Subject: RE: BE/40/21/HH 7 Cygnet Walk, Bersted

I am looking over your application for extensions at the above property. I have not been able to undertake a site visit to this property therefore please can you send me in some site photos of the existing property and location of proposals please?

SITE PLAN - 1/500

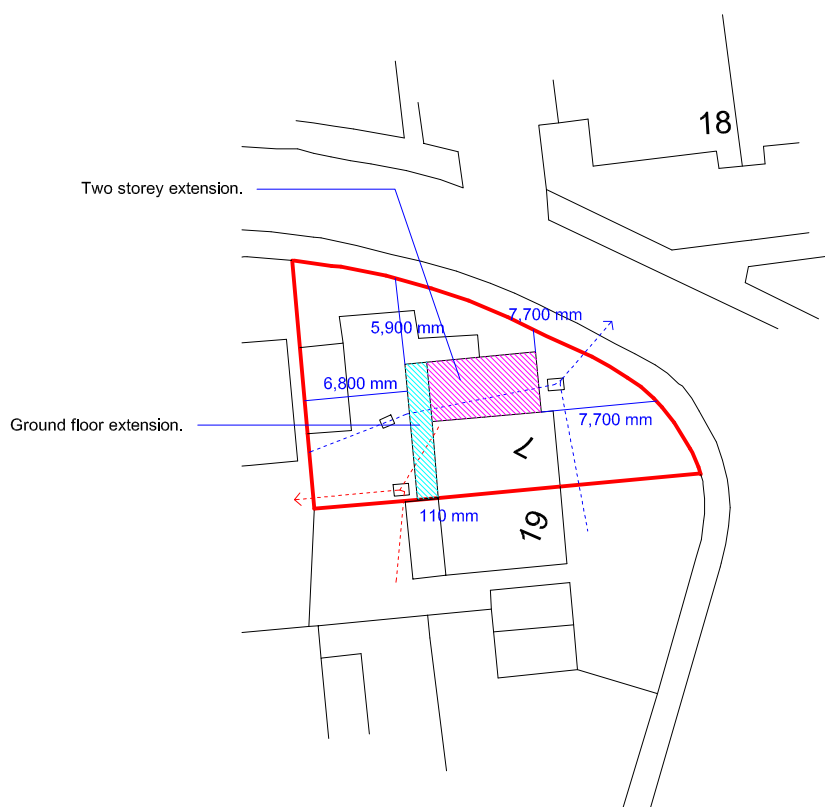
Also can you confirm – will there be access remaining to the rear garden area – on Proposed Ground floor plan shows a gap remaining to northern boundary wall but block plan does not show this gap?

The attached photos I hope show you what you need (these are all I have) – there is a 1.8 metre fence at the boundary of No. 19 Hawks Place and to the southern boundary. The existing rear access by the garage will remain – see photo.
